From: Laura Gibbons
Sent: 30 August 2019 16:01
To: Planning.Responses <Planning.Responses@arun.gov.uk>
Cc: Maria Tomalova <Maria.Tomalova@arun.gov.uk>
Subject: RE: Planning Consultation on: BN/66/19/PL

Engineers Comments Regarding Surface Water Drainage

APPLICATION NO: BN/66/19/PL
Registered: 15th August
2019
Site Address: Land off Canal Mews Barnham PO22 0AB
Grid Reference: 496310 104502

Description of Works: Erection of 3 No dwellings.

APPENDIX 5 – Sewage Treatment Plant Details

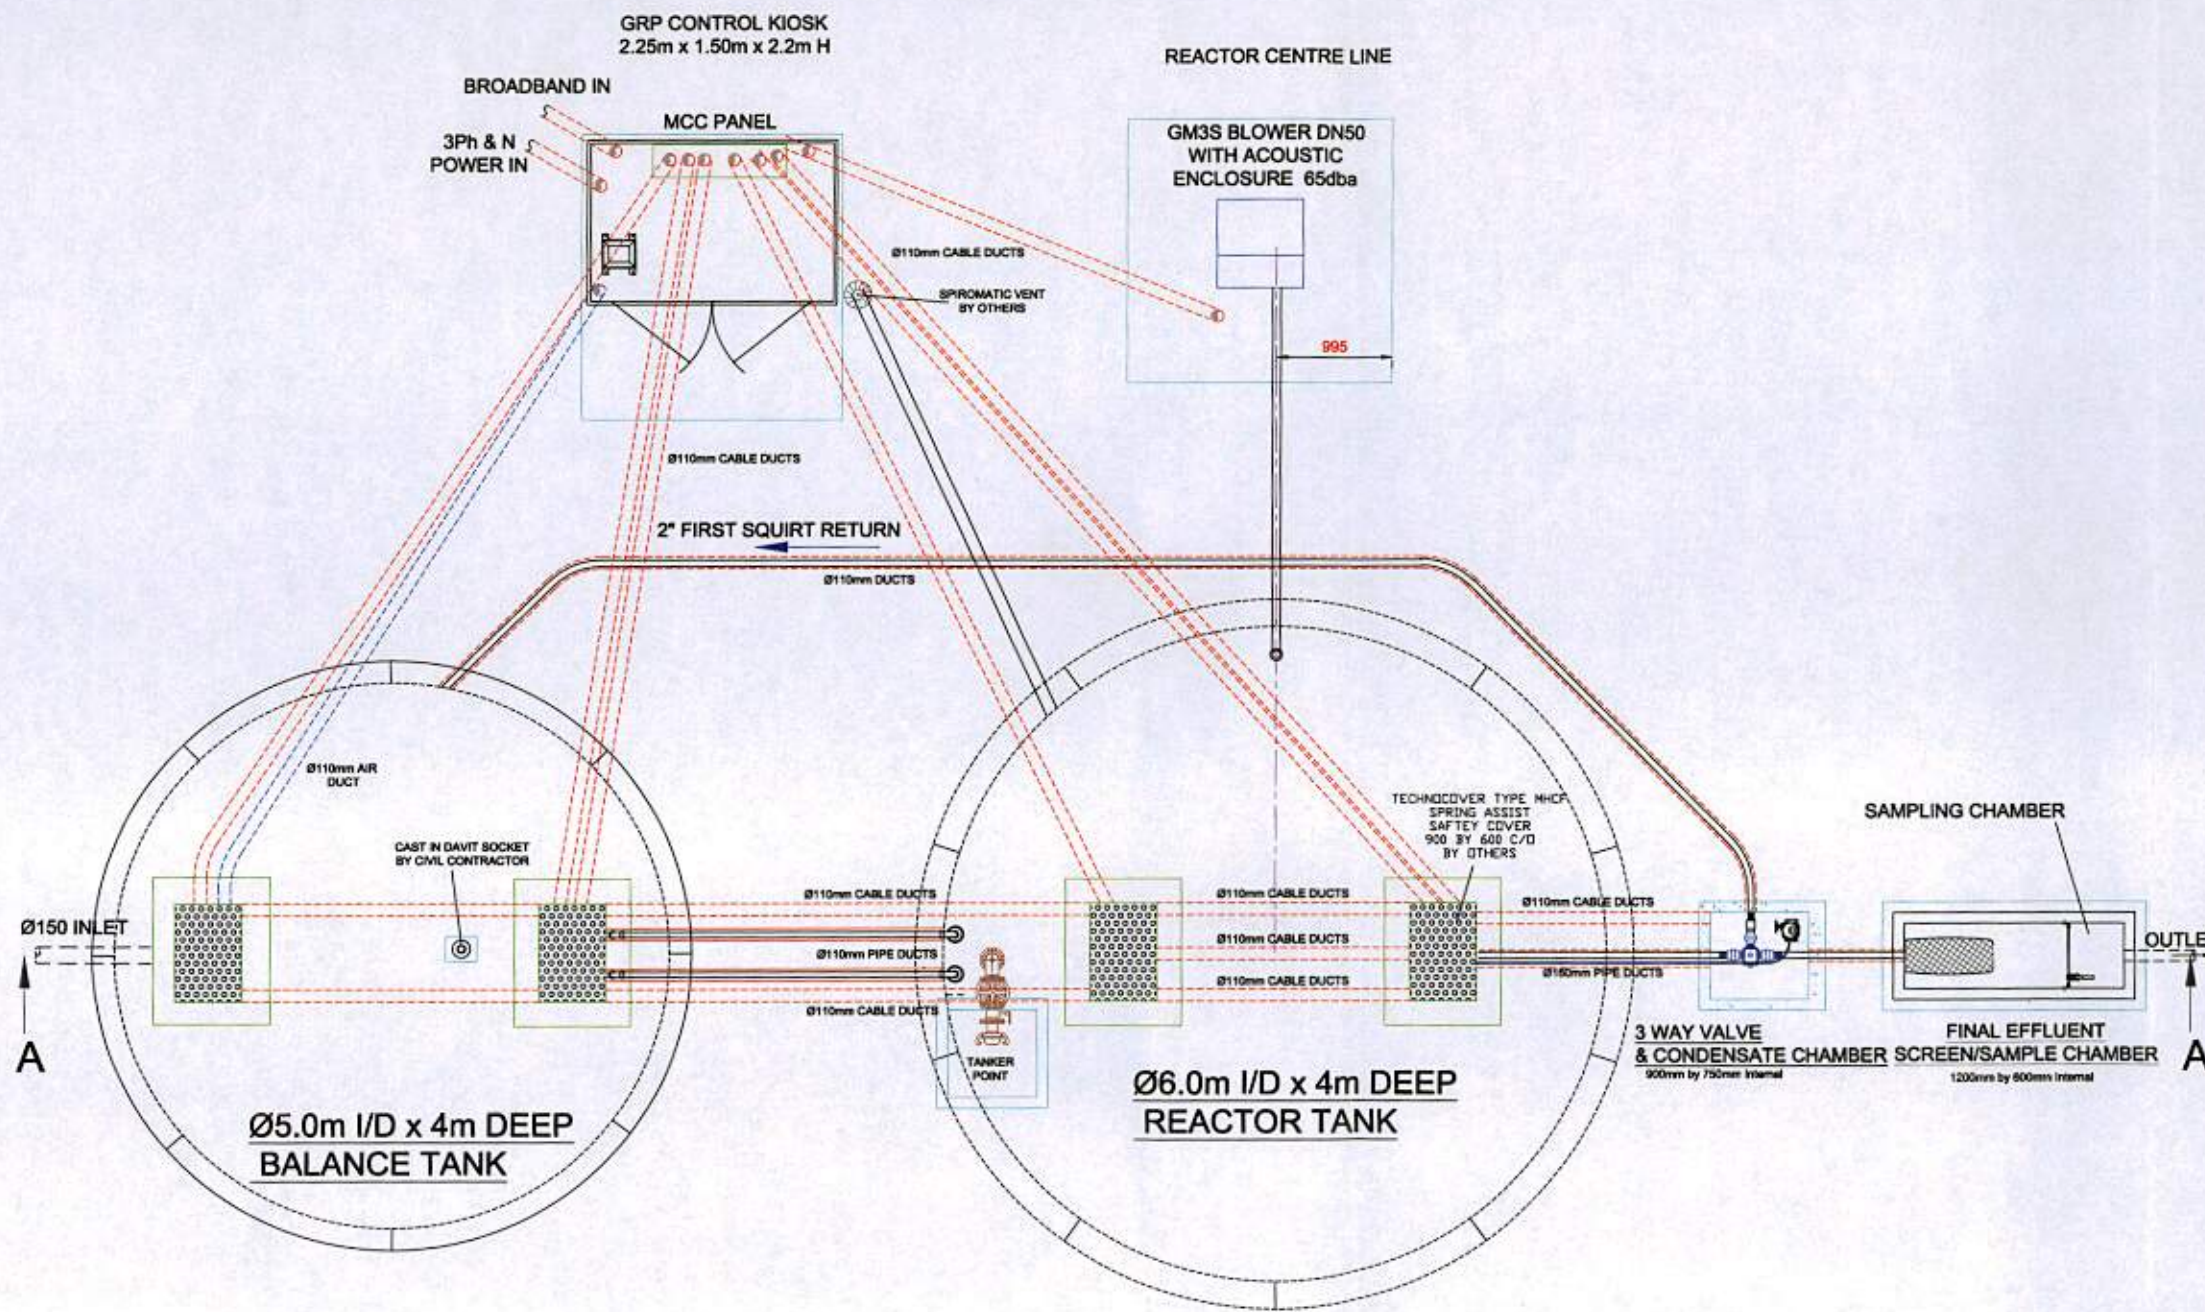
It appears that the documents submitted in support of a discharge of conditions application (reference BN/25/14/DOC) for the wider site indicate that a foul water treatment plant is located in the area of the proposed development. Please can the applicant confirm if this is the case or not. Until such time as this confirmation is provided we object to the application.
